Our Ref: SDNP/20/05541/ADJAUT
Contact Officer: Stella New
Tel. No.: [REDACTED]

Neighbouring Authority Consultation

Proposal: Adjacent Authority Consultation from Arun DC - Case Ref: A/109/20/RES - AMENDMENTS RECEIVED 3rd December to Approval of reserved matters following outline consent A/99/17/OUT for 175 No dwellings & associated infrastructure. This application may affect the setting of a listed building, may affect the character & appearance of the Angmering Conservation Area & falls within Strategic Site SD9, CIL Zone 1 (Zero Rated).

Address: Land South of Water Lane , Angmering

INDICATIVE SECTION

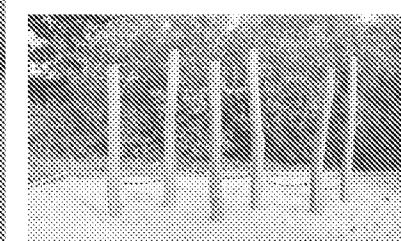
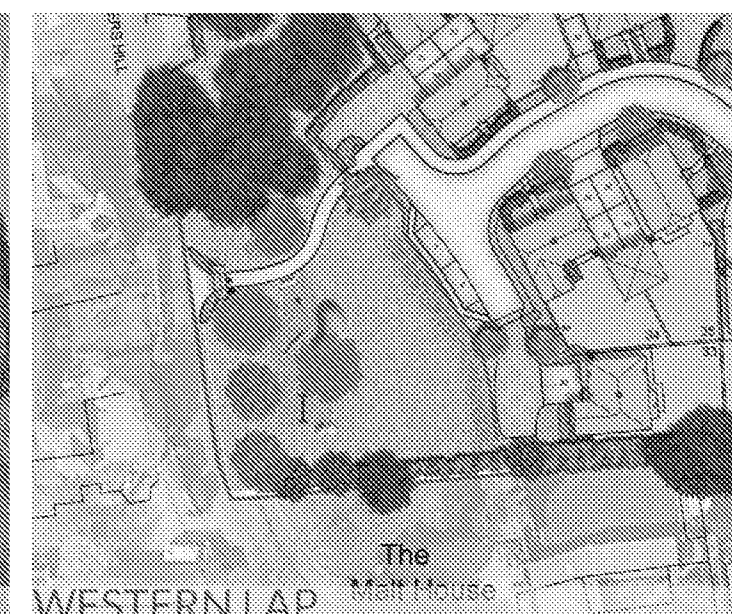
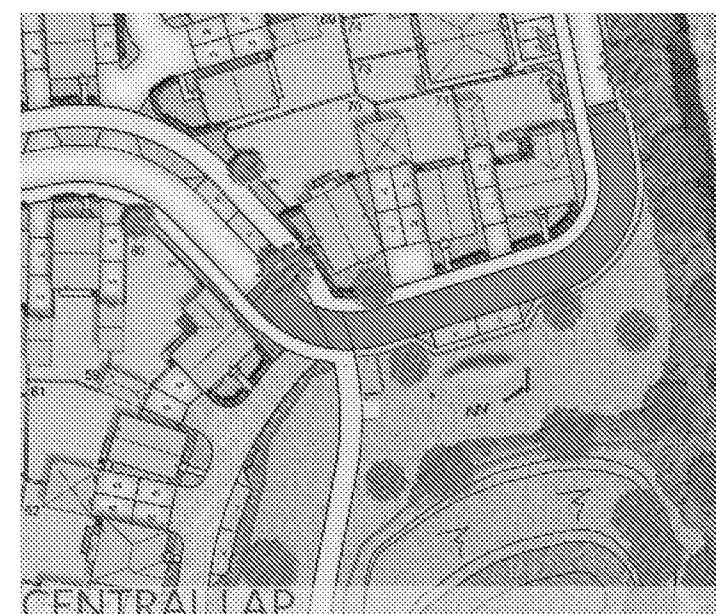
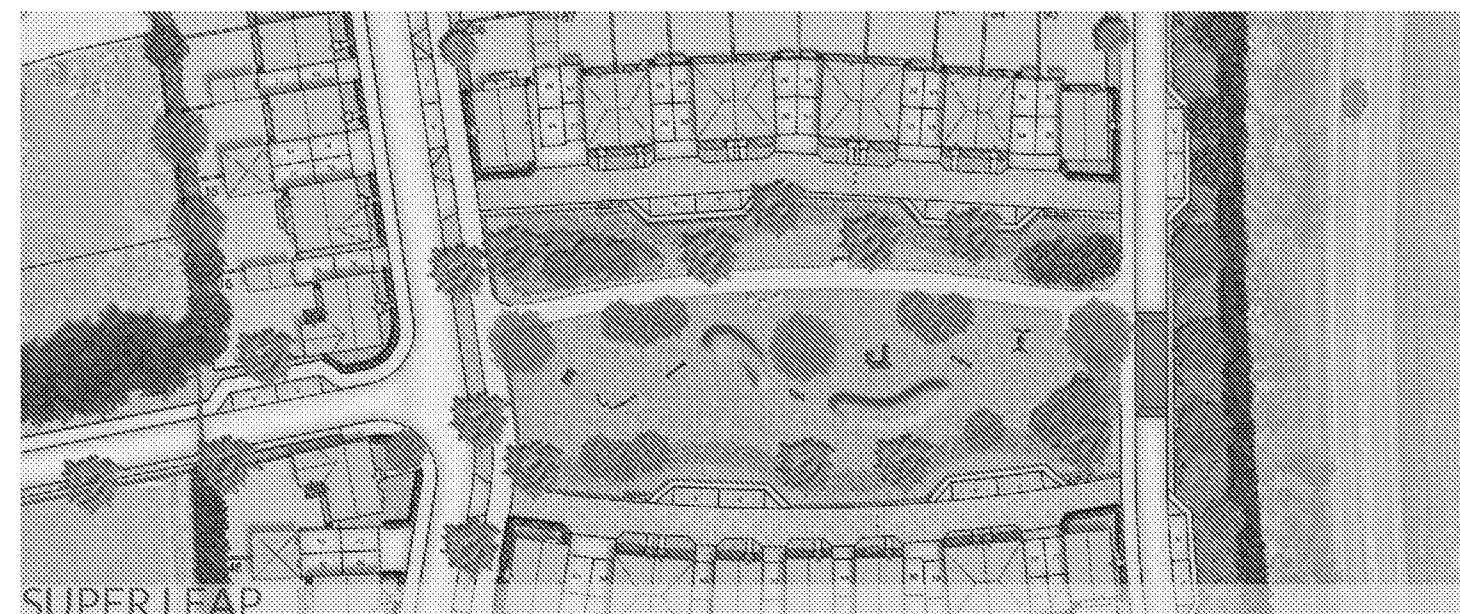
The revised Landscaping Master Plan appears to be broadly similar to previously submitted versions and predominantly urban in character. The planting scheme still indicates that a single line of trees would be provided along the western 'woodland' buffer, several of which are still proposed to be non-native ornamental or evergreen varieties. There is no assurance that the "Sussex View" character area would not retain "aspect over the National Park" and achieve "scenic views of the National Park" as previously stated in the Design and Access Statement, indicating that the buffer would be sufficiently sparse and/or broken up to allow clear views out of the site; or that the dwellings in this area would not be light in colour (render or weatherboard?) and therefore more eye-catching in the landscape.

The number of visitor parking spaces within the western buffer appears to have been reduced to 2No, which is welcomed; however, the Authority remains of the view that this important buffer has been reduced to the minimum possible by the applicant to the point where it is likely to be incapable of serving its primary screening purpose, and it should not be minimised further by the provision of any parking spaces. The detailed landscape proposals include two dotted black lines within the western buffer either side of what is presumed to be the red edge which is also dotted; however, these are not annotated and it is unclear what they indicate - are these services routes? It also remains unclear how the buffer will assist in protecting commuting badgers, as required by condition 10 attached to the permission if parking spaces continue to be provided.

INDICATIVE SECTION

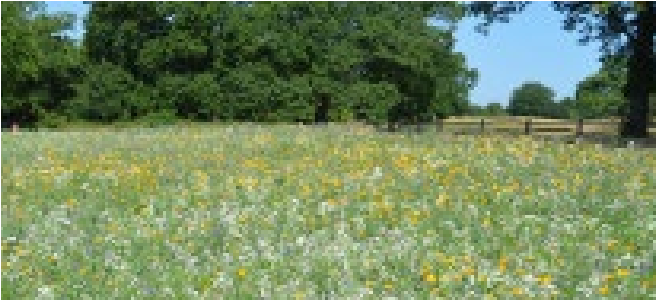
The revised landscaping masterplan also annotates the eastern boundary by including depth measurements of the planted buffer which range from 7m to 15m. However, the measurements include the existing boundary hedge, as well as what appears to be a pedestrian access running the western edge of the buffer and, in some cases, what appear to be sections of private garden. No measurements are provided of the narrowest sections of the buffer where the visitor car parking spaces are provided.
